From: Simon Davis
Sent: 03 February 2021 12:11
To: Planning Scanning
Subject: Y/71/20/RES: Land North of C of E Primary School, Yapton

Application Correspondence "Re Layout Changes to Y/72/20/RES and EoT for Y/71/20/RES"

**PLANNING LAYOUT  
70 UNIT SCHEME**

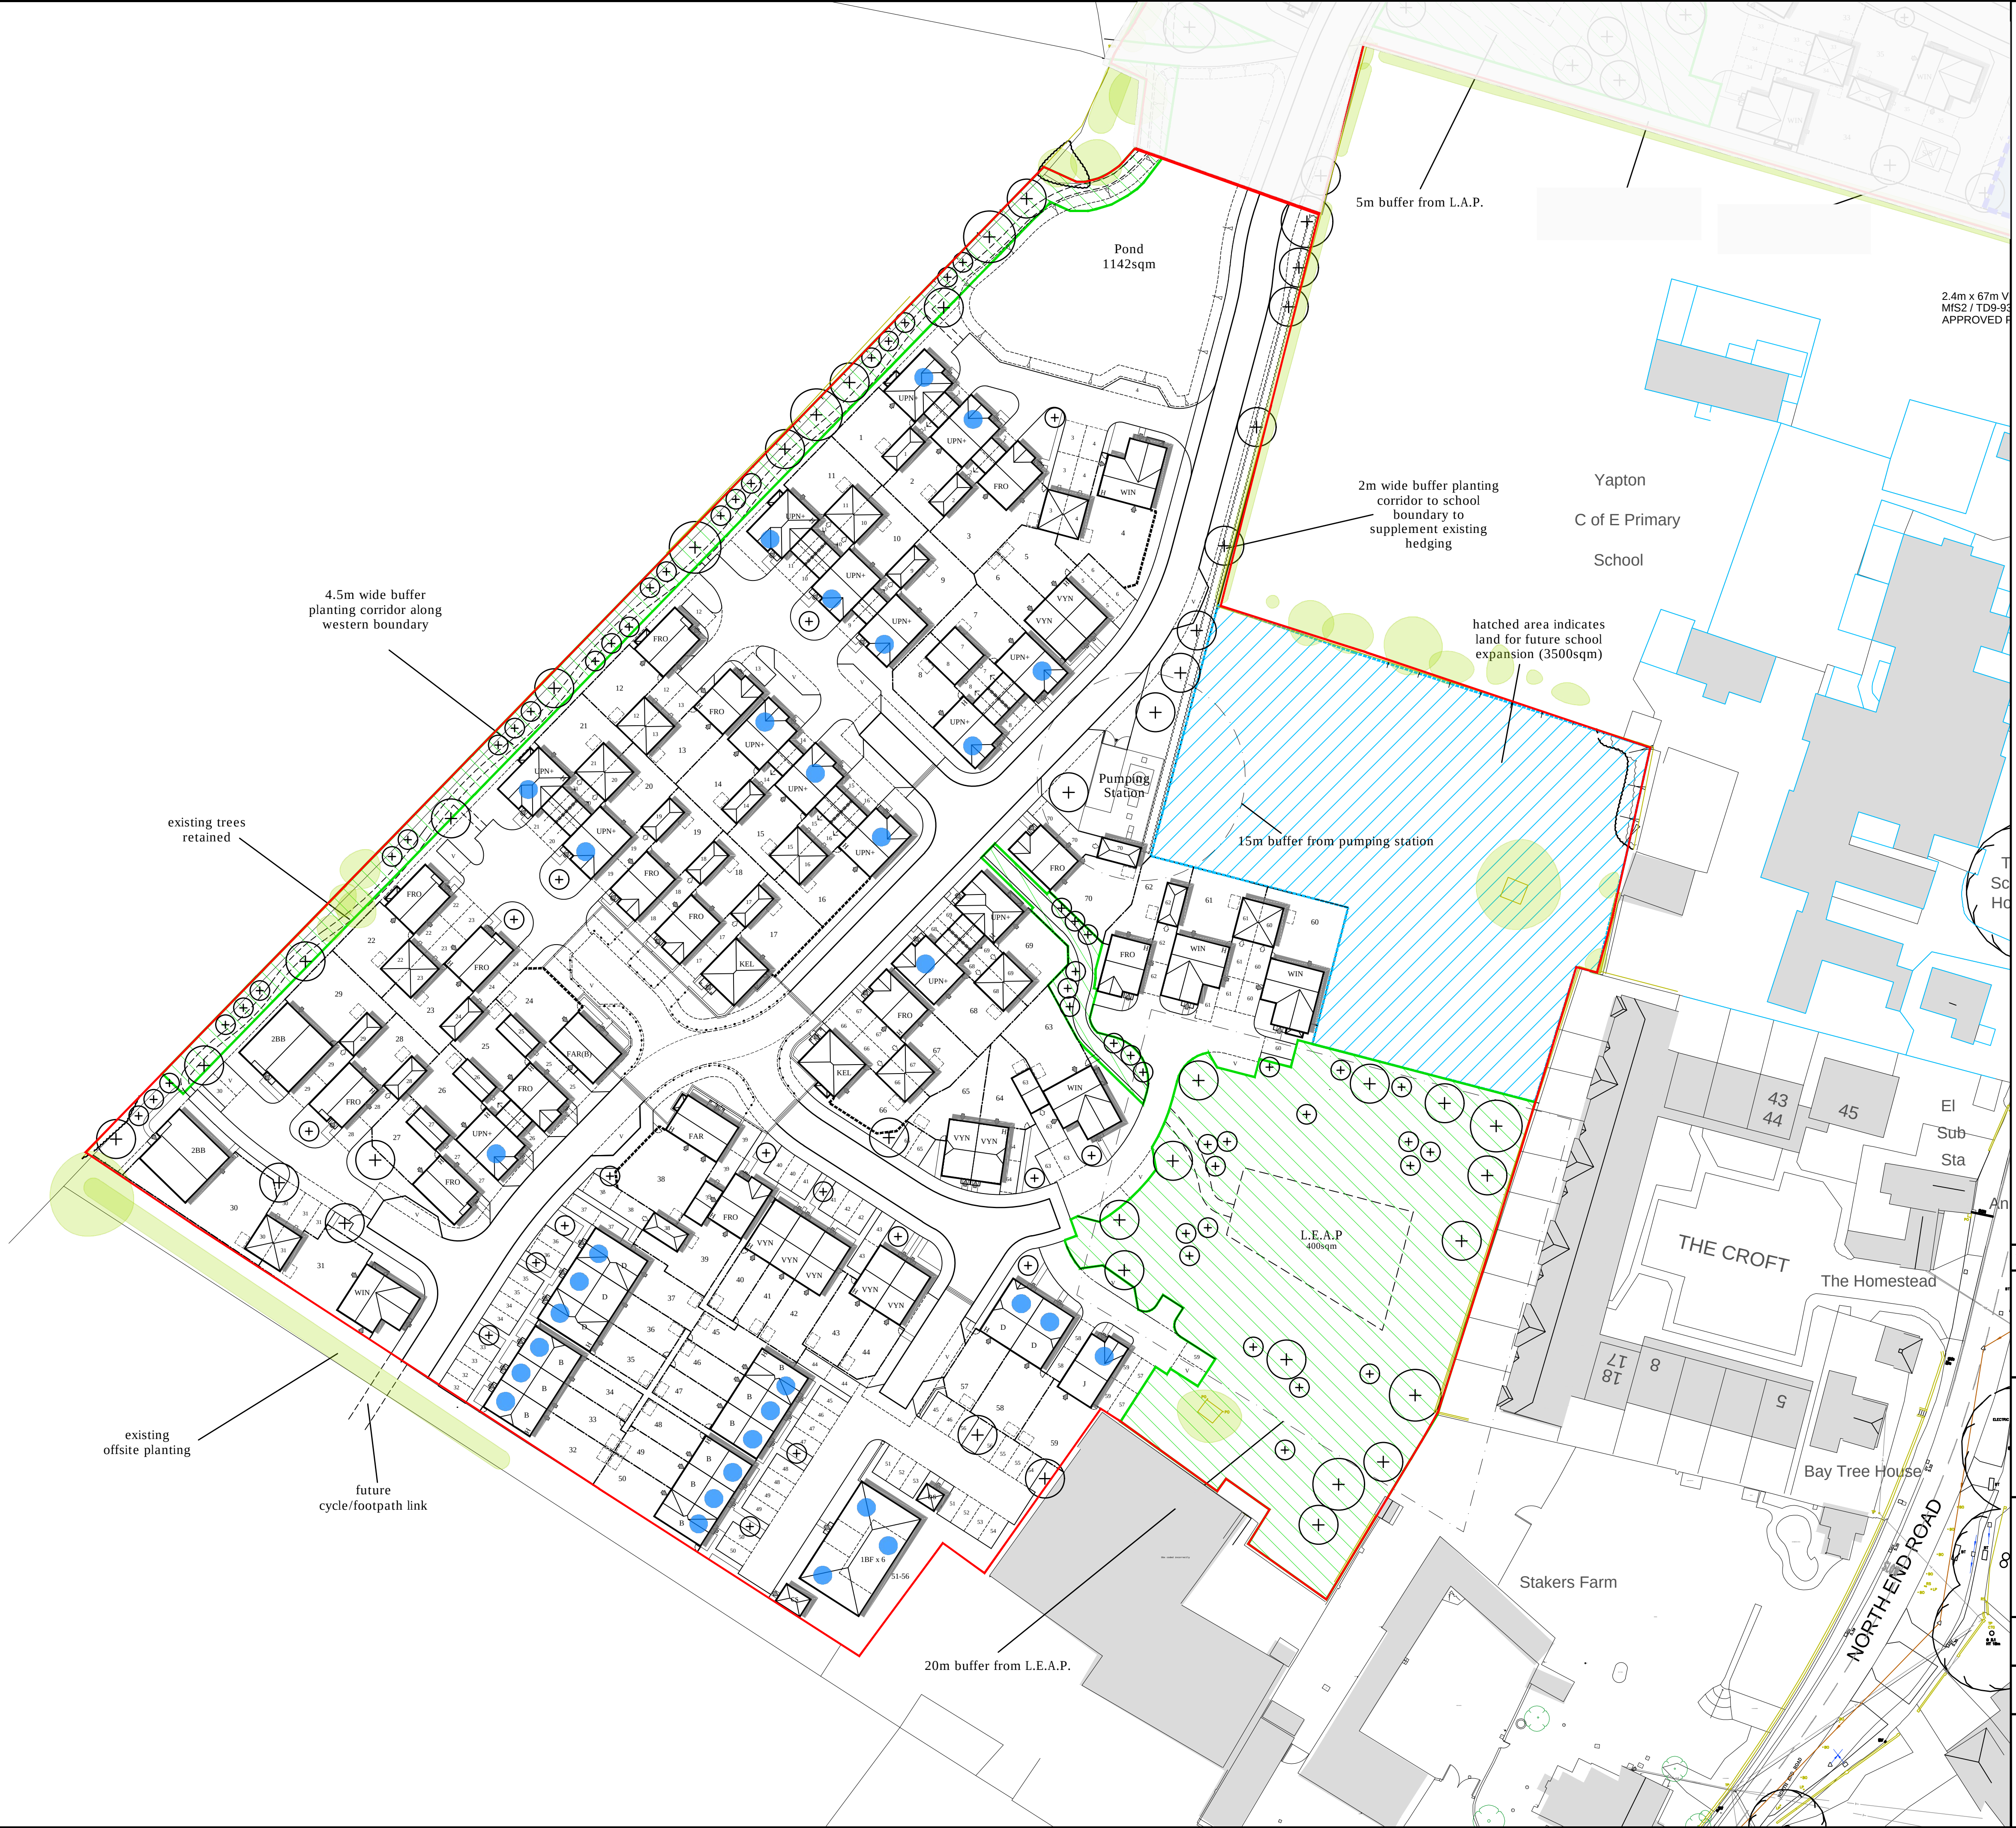
Regarding, Y/72/20/RES, I believe that our Director will be requesting that you change your layout so that the access onto the private track is directly opposite the access point from Bonhams Field. Currently, there is a dog leg arrangement between the two which we want to avoid. I had assumed this phone conversation had already taken place but it would appear not. Your MD may want to follow this up with Karl Roberts.
